Subject: Re: Application Ref 3/2025/0814 - Startifants Farm

Chipping Parish Council discussed application ref 3/2025/0814 at their meeting on 17th November 2025. The application proposes a car port situated adjacent to the road at Startifants Farm. Councillors felt that the scale of the proposed building, at 4m high to the apex, may have an impact on visibility for road users, particularly those turning out of Startifants Farm and neighbouring properties.

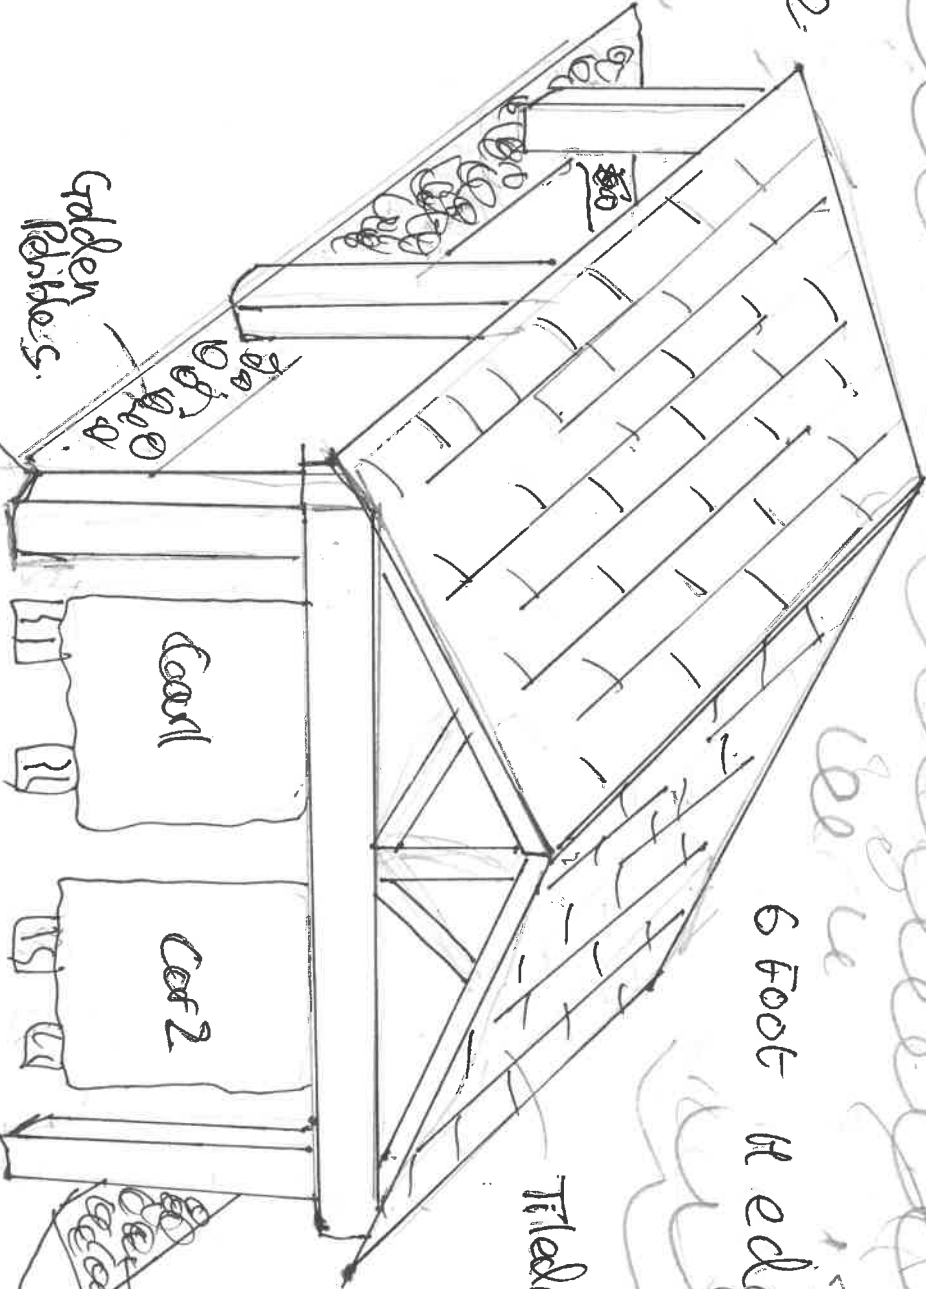
In addition to the comments below it has been pointed out that the application refers to a 6ft high hedge. The PC considers that the hedge height combined with the placement of the proposed carport may reduce visibility for cars emerging on to the road. We ask that these concerns are considered by LCC Highways and suggest that a restriction should be imposed on the hedge height.

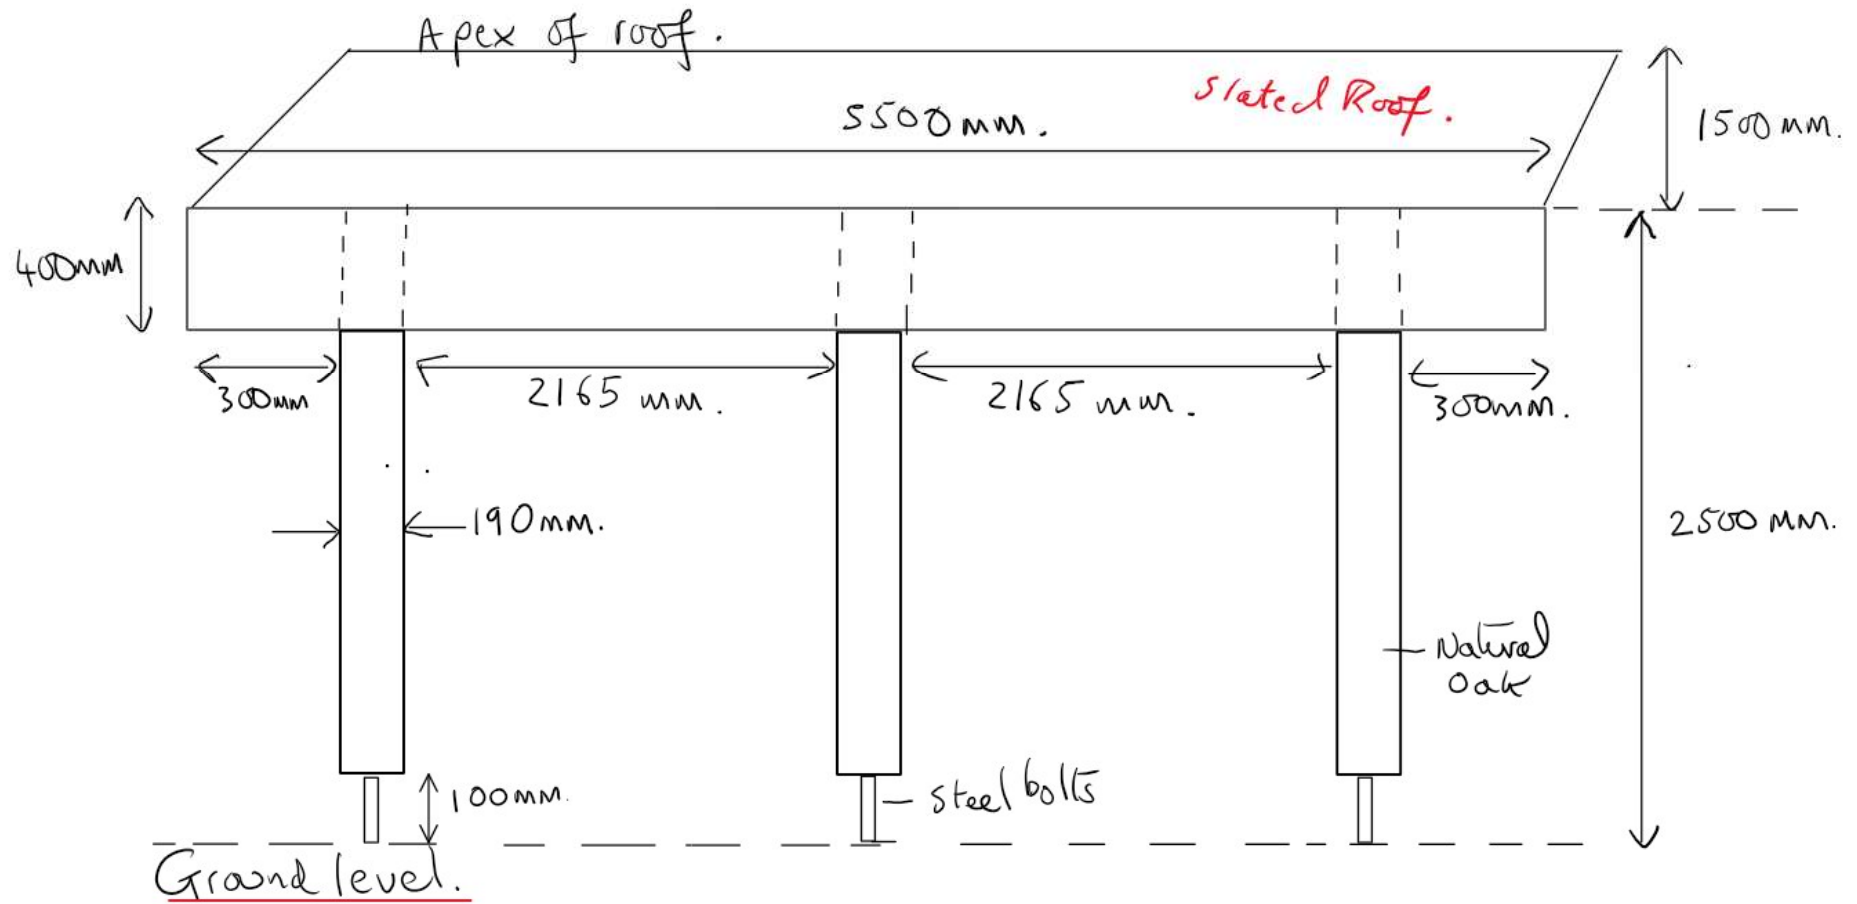
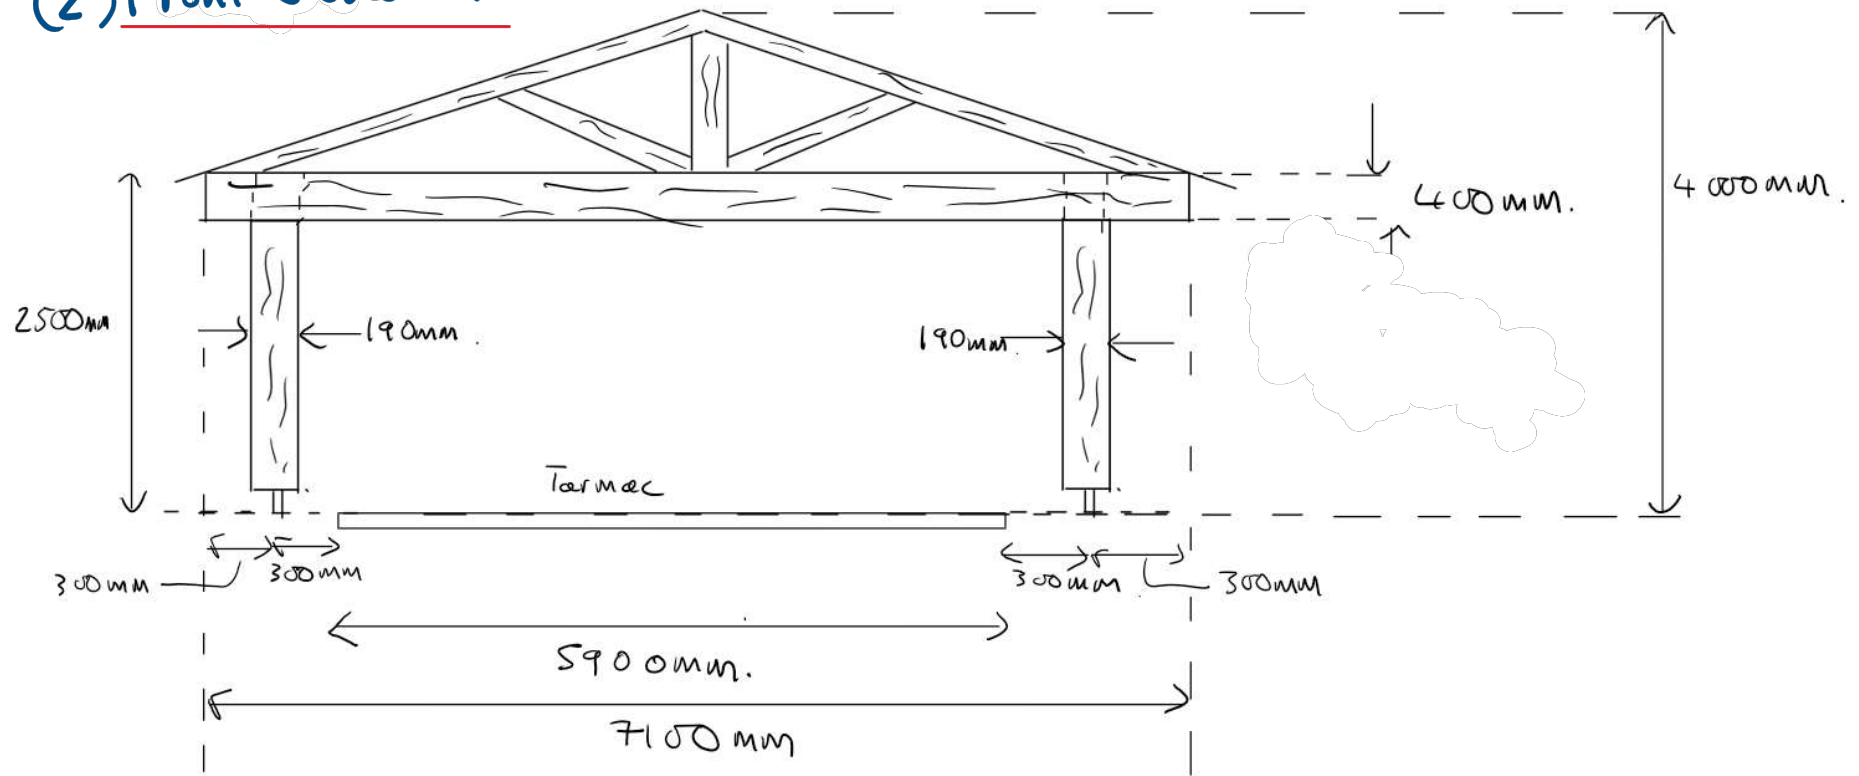
We ask that LCC Highways consider the position and size of the proposed building regarding visibility of approaching traffic from exits on to the highway as it is not clear from the drawings included with the application if there will be a negative impact.
